**WELWYN HATFIELD BOROUGH COUNCIL
EXECUTIVE DIRECTOR - PLANNING, PUBLIC PROTECTION AND GOVERNANCE**

Application No: 6/2020/1714/HOUSE
Location: 86 Bell Lane, Brookmans Park, Hatfield, AL9 7AY
Proposal: Erection of two storey front extension
Officer: Mr Tom Gabriel

Recommendation: Refused

Proposed Location & Block Plan

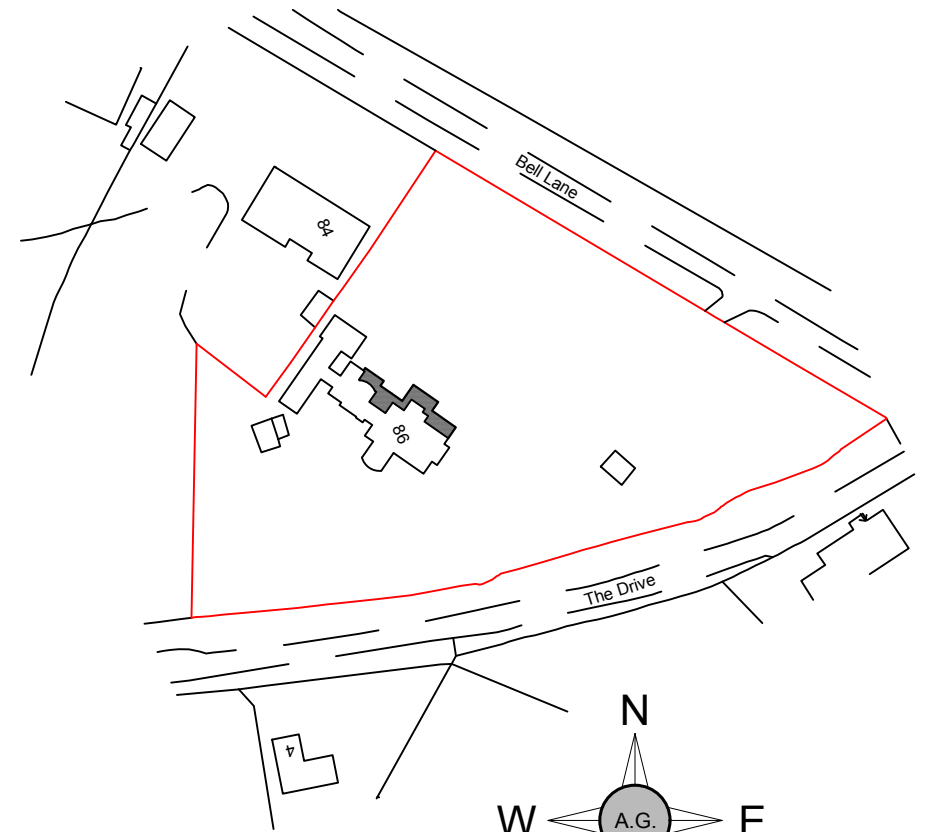
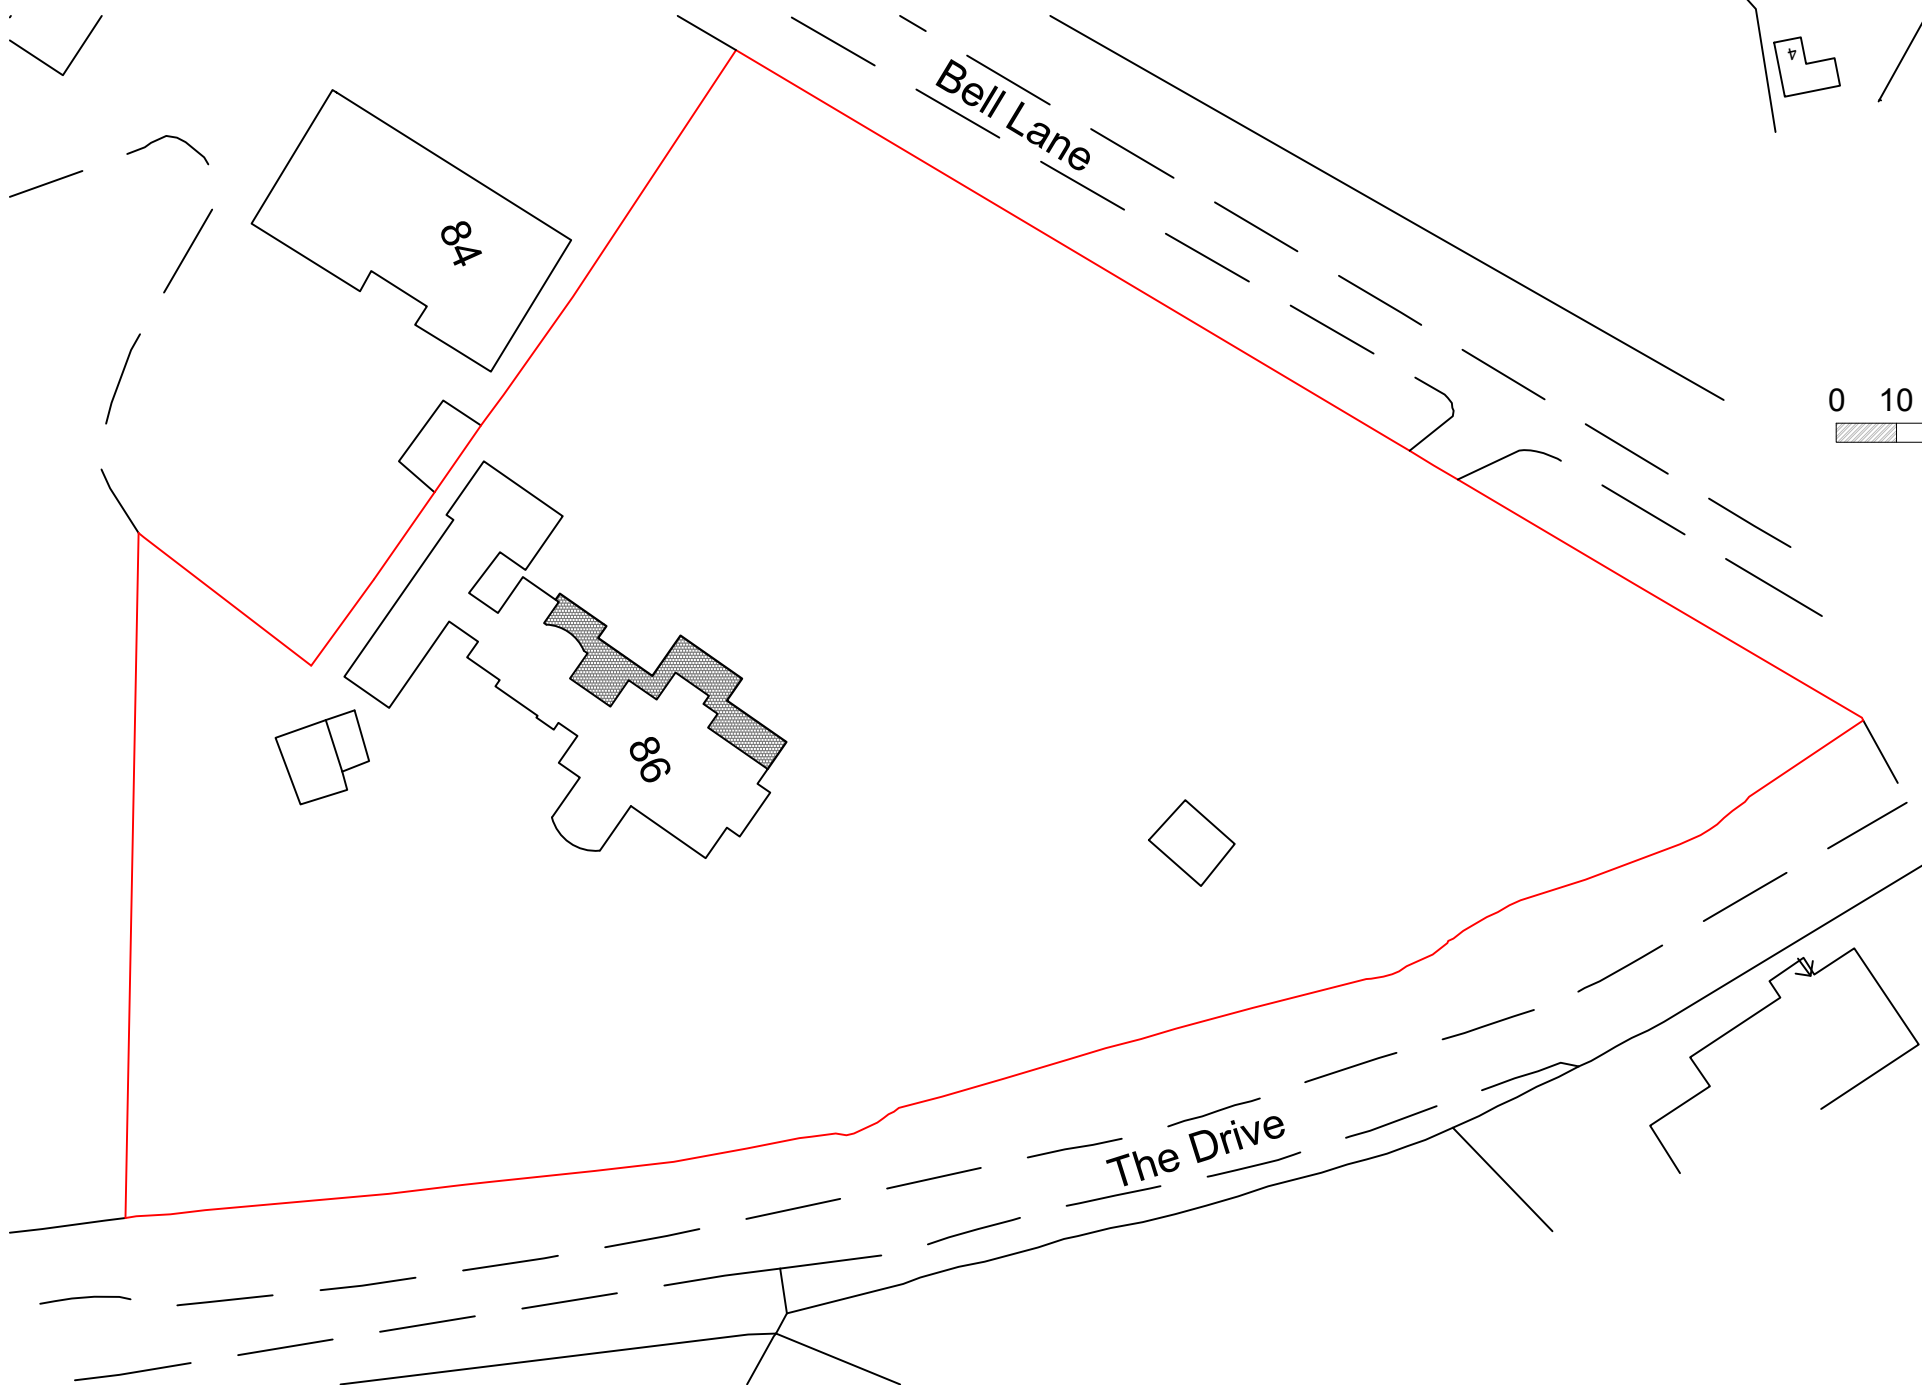
The proposal would represent inappropriate development within the Green Belt. In addition to this harm, there would also be harm to the openness of the Green Belt. No very special circumstances exist which outweigh the harm to the Green Belt by reason of inappropriateness, and the other harm identified. Furthermore, insufficient information has been provided with the application to fully consider the impact of the proposal on bats.

1. The proposal would result in disproportionate additions over and above the size of the original building and, therefore, is inappropriate development in the Green Belt. In addition, there would be a loss of Green Belt openness. No very special circumstances exist to clearly outweigh this harm. Consequently, the development conflicts with Policies GBSP1 and RA3 of the Welwyn Hatfield District Plan 2005 and the National Planning Policy Framework.
2. Insufficient information has been provided with the application to fully consider the impact of the proposal on bats. As such, the appropriate assessment in terms of the Habitats Regulations cannot take place and the proposal cannot be properly considered against Policy R11 of the Welwyn Hatfield District Plan 2005, Policy
